Re: Judge Orr Road Commercial Park Traffic Impact Study

Please see the JR Engineering comment responses to the comments received on April 10, 2026 for the Judge Orr Road Commercial Park Traffic Impact Study. The comment responses are in red italics.

Figure 4 - 2028 Opening Day Proposed Lane Geometry

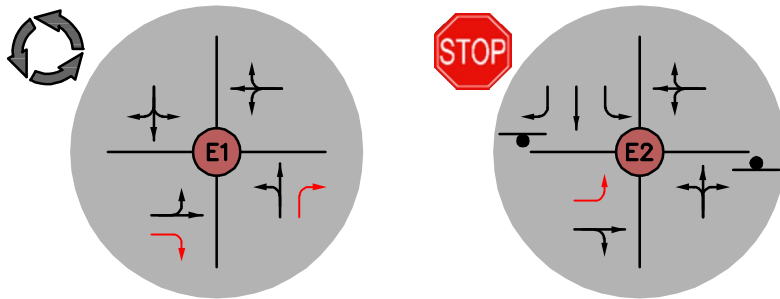
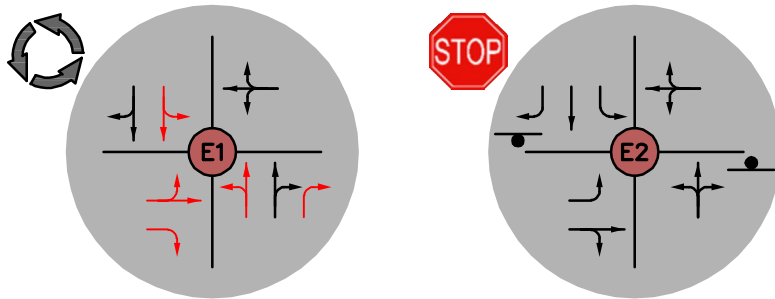
1. The site generates 4,182 daily trips with the majority using the future US24 & Judge Orr roundabout. The site build out traffic operations analysis show a significant degradation in the roundabout Level of Service (LOS). The lane configuration used for the TIS evaluation is incorrect leading to poor levels of service for the northbound and eastbound approaches. These approaches both have a free right which should improve roundabout operations.

Please rerun the analysis and revise the Traffic Impact Study to reflect the comments above and resubmit for review.

JR Response: The TIS has been updated to include free rights for the NB and EB approaches of the roundabout. As expected, this improved traffic operations.
